Consultation Response from KC, Conservation and Design		
2021/93007 Yew Tree Farm, 63, The Village, Farnley Tyas, Huddersfield, HD4 6UQ		
Listed Building Consent for conversion of existing barn to form 8 dwellings, erection of 10 dwellings, demolition of redundant agricultural buildings and associated works (Listed Building within a Conservation Area)		
Date Responded: 7.10.21	Responding Officer: Sue Brooks	Responding Ref:

DRAWING TITLE
PLOT 11

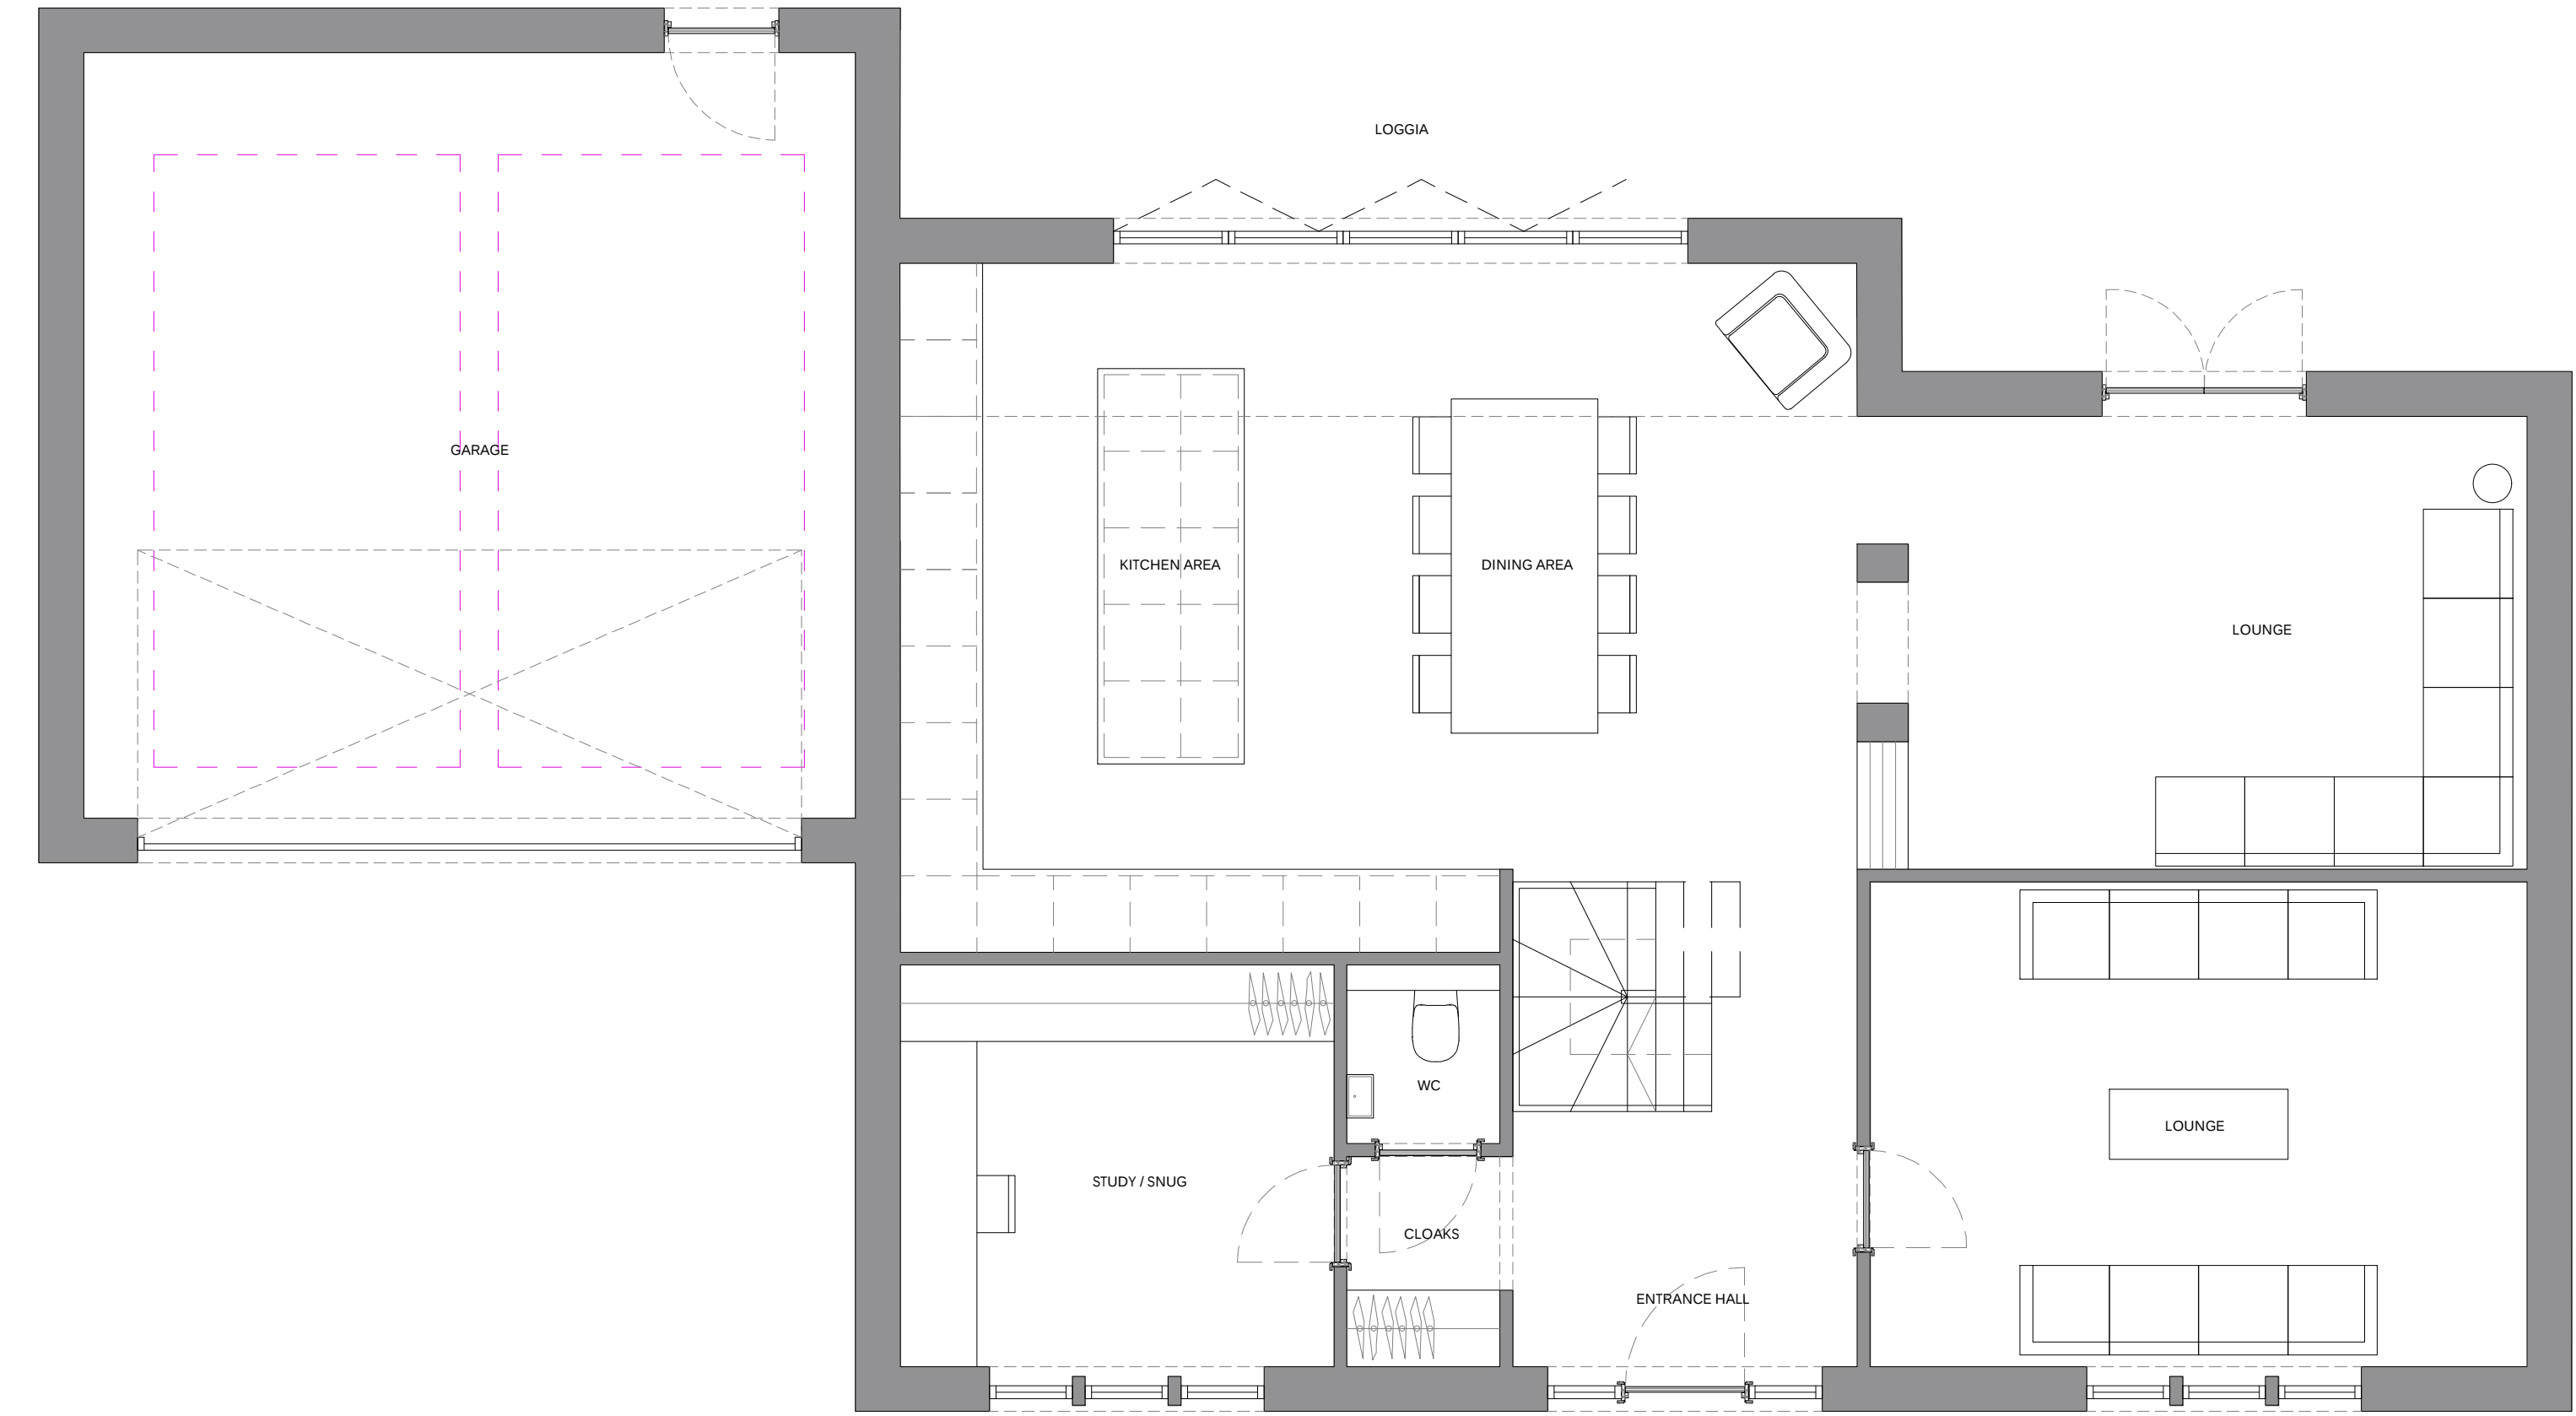
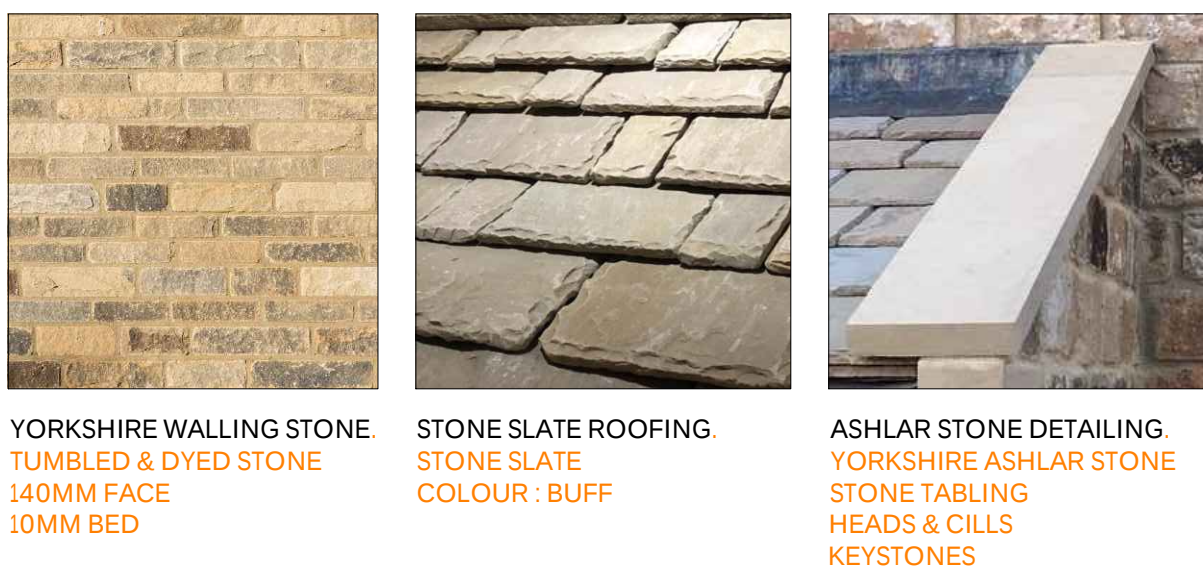
Four separate dwellings are proposed within this barn, which is towards the northern end of the site, with first floors inserted and extensive subdivision. This will result in a loss of openness which is characteristic of this type of farm building and will lead to harm to its significance. We would suggest that the design of the conversion is revisited to retain this character, perhaps with a reduction in the number of units and mezzanines inserted to retain the sense of space.

No assessment has been made to show the impact of the subdivision on the significance of the barn, the level of harm caused and public benefits to outweigh the harm. No details have been submitted to show how the proposed interventions will interact with historic internal details such as trusses and how historic internal features will be retained and incorporated into the proposals.

The removal of the round timber window shutters and timber barn doors on the north-east elevation is proposed, with the insertion of windows within these openings, along with the insertion of new window openings in this elevation. Little consideration has been given to the agricultural character of the building, with these interventions resulting in the loss of the characteristic details of this barn, particularly on this prominent and significant elevation. No justification, materials or details have been submitted.

The alterations to the west elevation also cause harm to the significance of the building. The significance of the mono-pitch stone extensions has not been assessed and their demolition has not

been justified. In addition, the insertion of new doorways with porches and new window openings creates an overly domestic appearance with no consideration given to the agricultural character of the building, and again these have not been justified. No details or materials have been submitted.

The number of proposed roof lights is excessive and is not supported. As above, they do not consider the significance of the building, they have not been justified, and alternative less harmful layouts have not been proposed.
